Application for a non-material amendment following a grant of planning permission.
Town and Country Planning Act 1990

PROPOSED CHANGE OF USE FROM CHURCH, SHOP AND
ANCILLARY ACCOMMODATION TO THREE ONE BEDROOM
DWELLINGS INCLUDING EXTERNAL ALTERATIONS TO
THE BUILDING CONSISTING OF NEW WINDOWS AND ROOFLIGHTS

3/2024/0363

RE-OPENING OF HISTORIC WINDOW AT GROUND FLOOR
FACING KING LANE

PROPOSED SOUTH WEST (KING LANE)

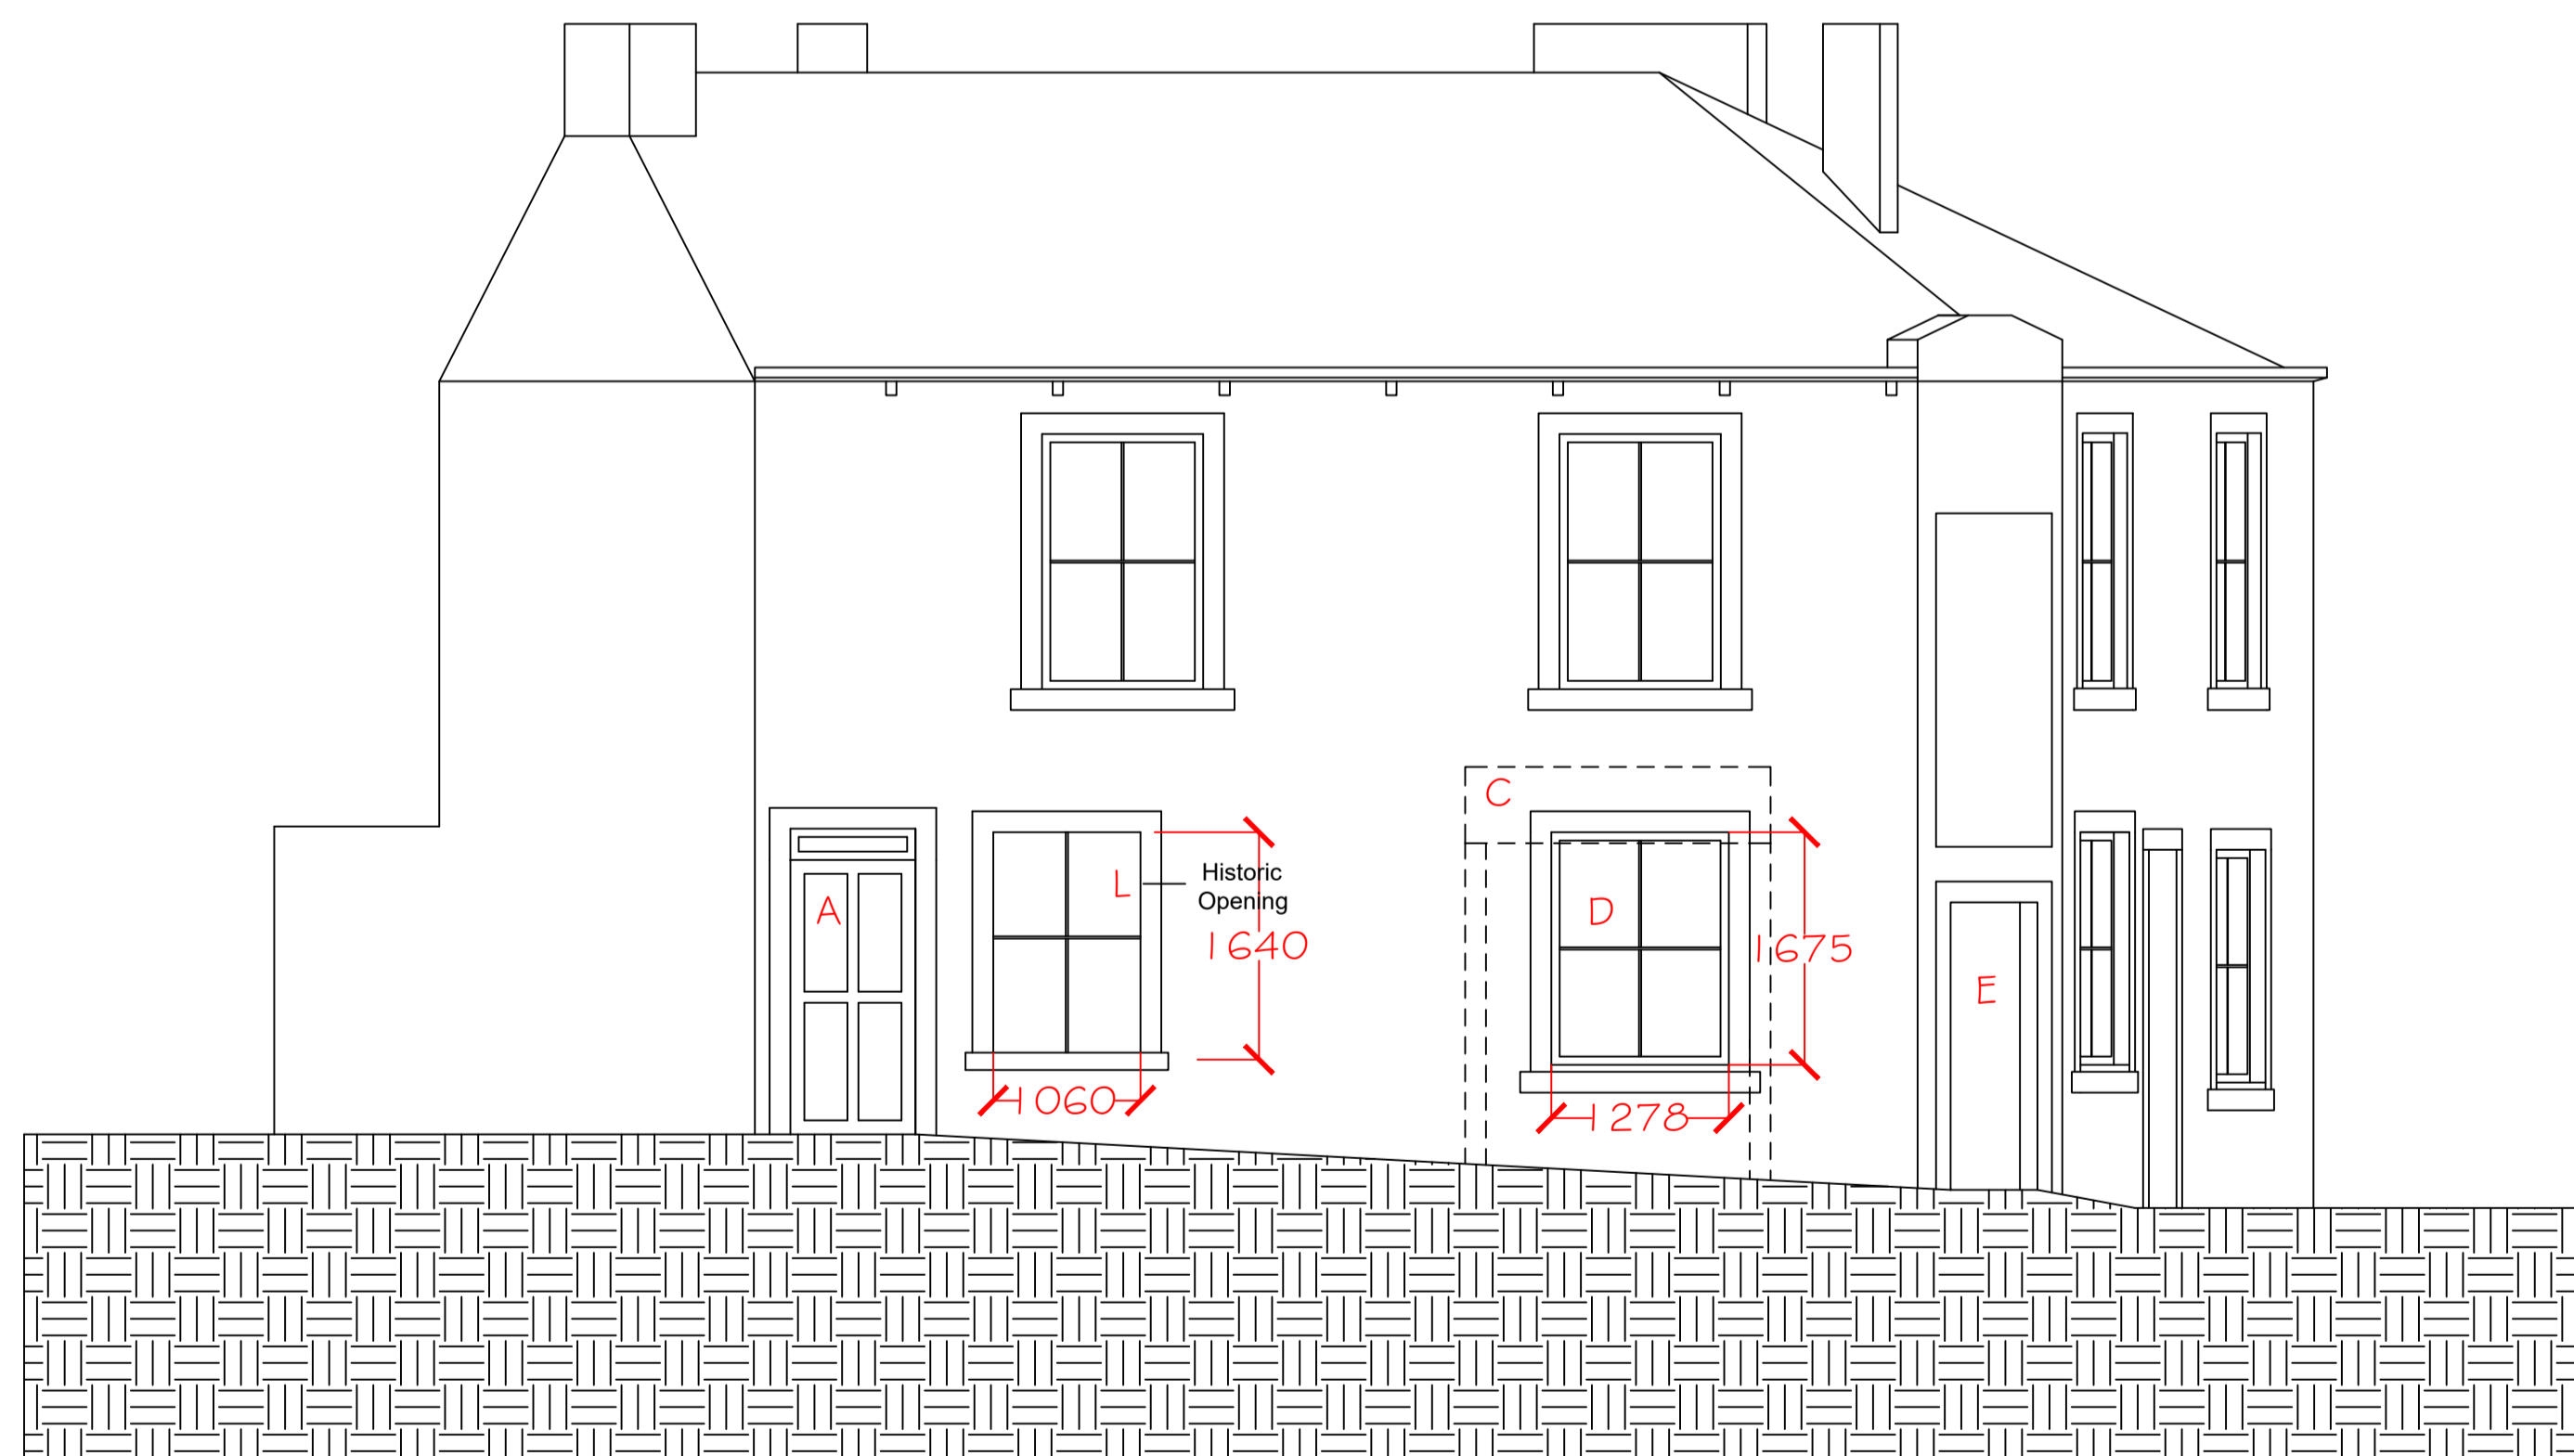
PROVIDE NATURAL LIGHT INTO THE STAIR AND TO
RETURN THE BUILDING BACK TO IT'S ORIGINAL WINDOW
